Our Case Number: ABP-319013-24

Re: Replacement of existing biomass-fired boilers, biomass-fired thermal fluid heater and gas-fired thermal fluid heater at Medite's manufacturing plant.

Re: Notification under the Planning and Development Act, 2000, as amended.

SID Application: Medite Europe DAC: ABP-319013-24 - Replacement of the existing three wood biomass fired thermal energy systems serving MEDITE's two production lines with, 2 no. renewable energy, wood biomass fired Thermal Fluid Heaters with thermal capacity of 60MW and 30MW respectively: Redmondstown, Clonmel, Co Tipperary

Figure 12-2 Proposed Woodland Planting Area

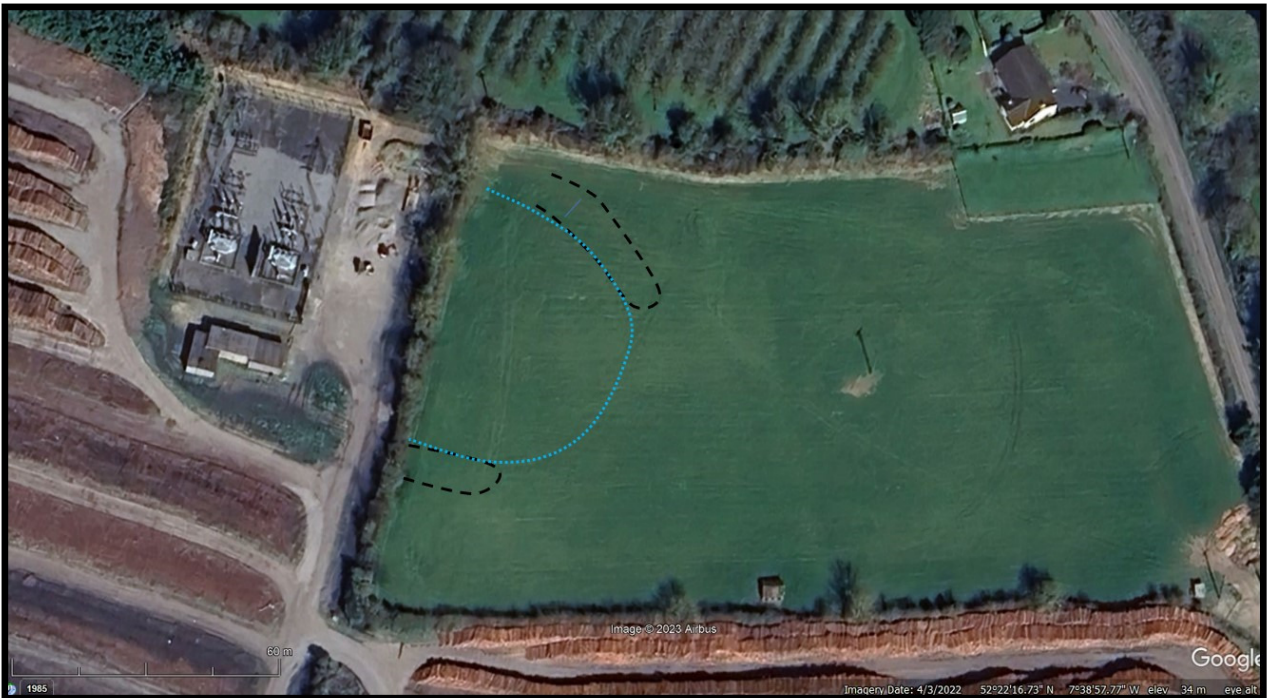
It is noted that field inspection carried out as part of the assessment has identified a low-relief earthwork in Area 4 of the Proposed Development Site (PDS). This may represent the remains of a circular to sub-circular enclosure and as such should be regarded as an area of very high archaeological potential with a strong likelihood that extensive sub-surface archaeological features or deposits could be present in addition to the upstanding low-relief earthwork remains. Known archaeological sites with similar morphology can date from a range of periods (both prehistoric and early historic); while some may be settlement sites, others have had ritual or funerary uses. It is noted that the footprint of this earthwork feature as identified in the field survey lies partially within the area proposed for native woodland planting to replace the stand of trees that would have to be felled in Area 2 of the PDS to facilitate the proposed development. It is noted that no advance archaeological geophysical survey or advance archaeological test excavation has been carried out to better understand the character and full extent of this site and to further inform the assessment.

Afforestation/tree-planting would have a significant direct negative impact on any upstanding and sub-surface archaeological features within the area where new woodland is proposed (see EIAR Section 12.57), this will include a substantial section of this new earthwork site. It is noted that Section 12.64 of the EIAR proposes that a programme of archaeological monitoring of construction-stage groundworks (including the tree-planting programme) would be sufficient to mitigate the impact to this earthwork site and its associated area of archaeological potential. The Department, however, advises that more detailed assessment of this earthwork site should be carried out prior to the commencement of construction (and any new landscaping/tree-planting). The Department advises that this should be done by way of a programme of archaeological geophysical survey and archaeological test excavation within Area 4 of the PDS.

2. The developer shall engage a suitably qualified archaeologist (licensed under the National Monuments Acts) to carry out a pre-development Archaeological Geophysical Survey and a pre-development Archaeological Test Excavation at Area 4 of the development site and to submit an archaeological impact assessment report for the written agreement of the planning authority, following consultation with the Department, in advance of any site preparation works or groundworks, including site investigation works/topsoil stripping/site clearance and/or construction works. This shall be in addition to any mitigation measures outlined in Chapter 12 of the EIAR.
